# ENG-SP19003-R2-PDR-redlines.pdf Markup Summary

**PRELIMINARY  
UTILITY & PUBLIC  
FACILITY PLAN**

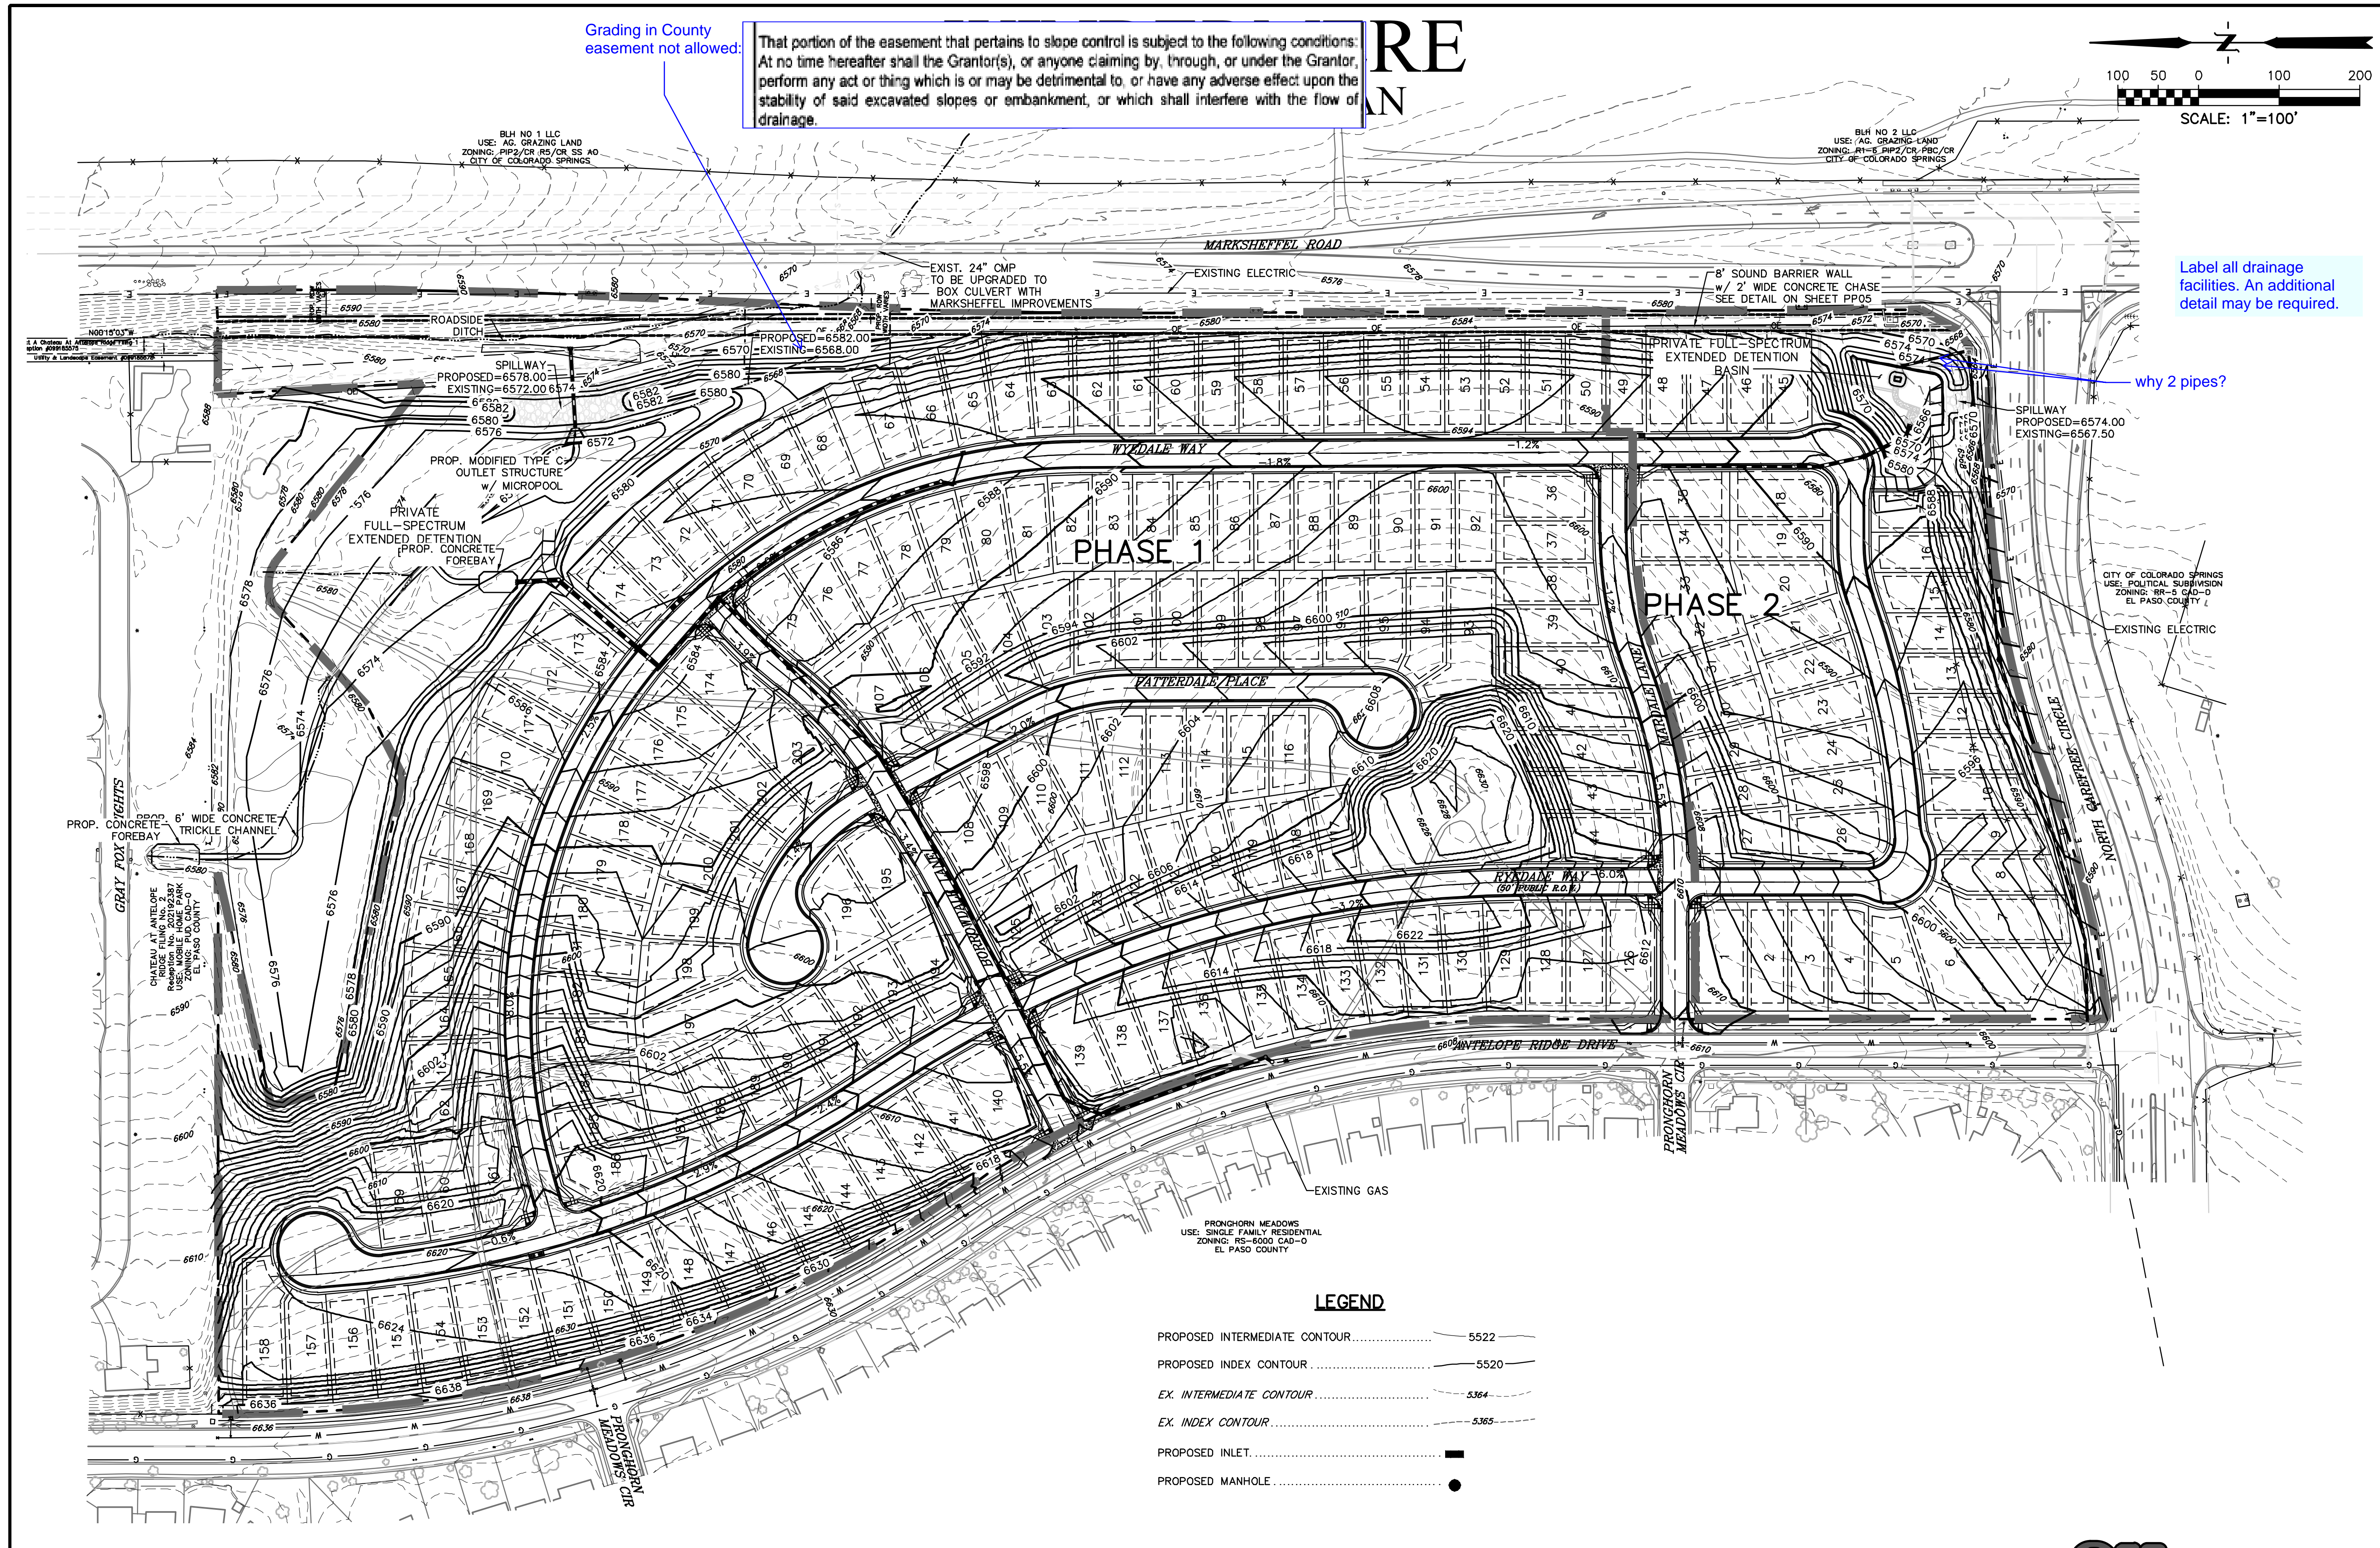
no grading in County easement
